From: [NectonSubstationAction Messenger](#)
To: [Norfolk Boreas](#)
Subject: Answet to Q9.0.2
Date: 14 December 2019 09:25:31

From: [NectonSubstationAction Messenger](#)
To: [Norfolk Boreas](#)
Subject: Responses to developers answers to Q9.1.1
Date: 14 December 2019 09:13:58

From: [NectonSubstationAction Messenger](#)
To: [Norfolk Boreas](#)
Subject: Q9.1.7
Date: 14 December 2019 09:38:33

Title:	Scenario 1 Viewpoint 4: A47 Necton Substation
--------	---

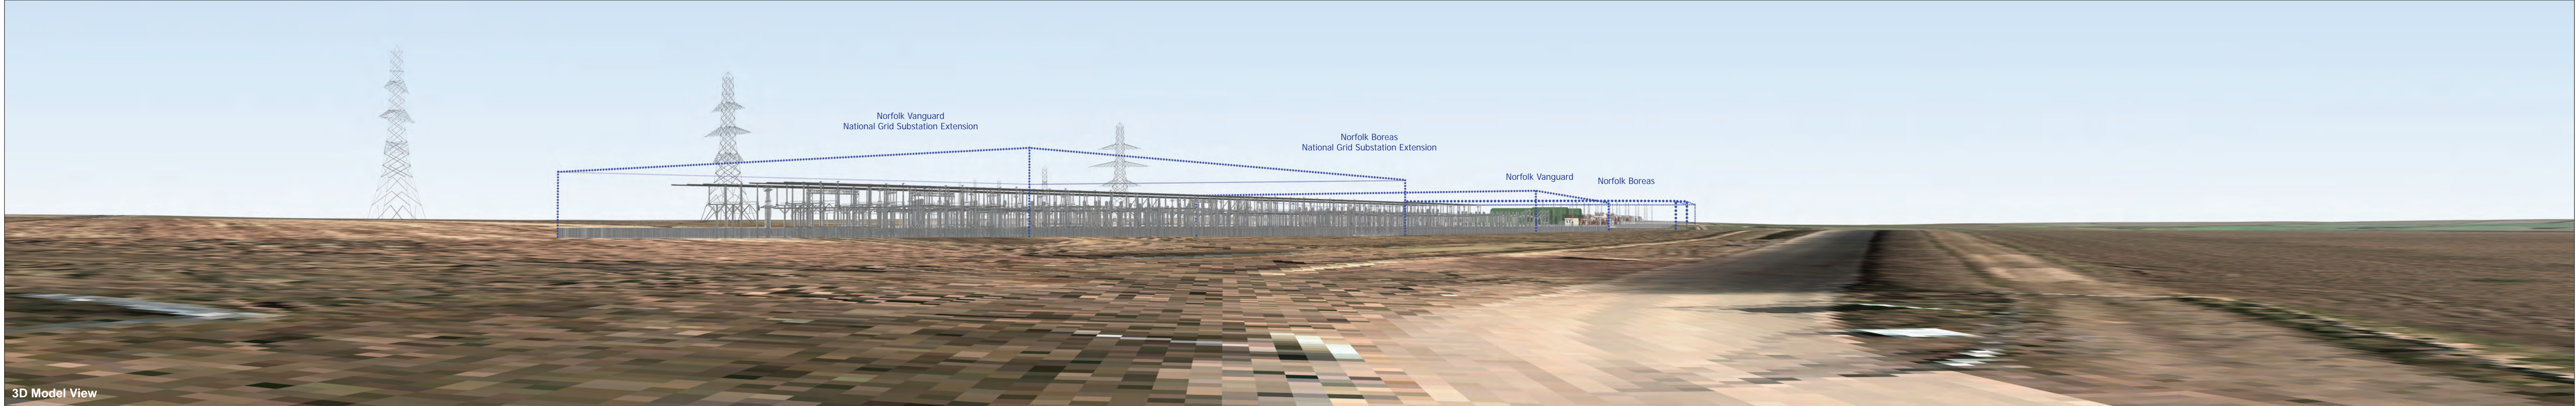
15. The computer simulations missed out the National Grid construction entirely (which will increase by up to 18 acres depending on whether both projects go ahead or just one), and the view provided in that direction depicted an untouched field-scape, which did not show the existing Dudgeon substation or the existing NG substation, or the National Grid Vanguard and Boreas extensions.
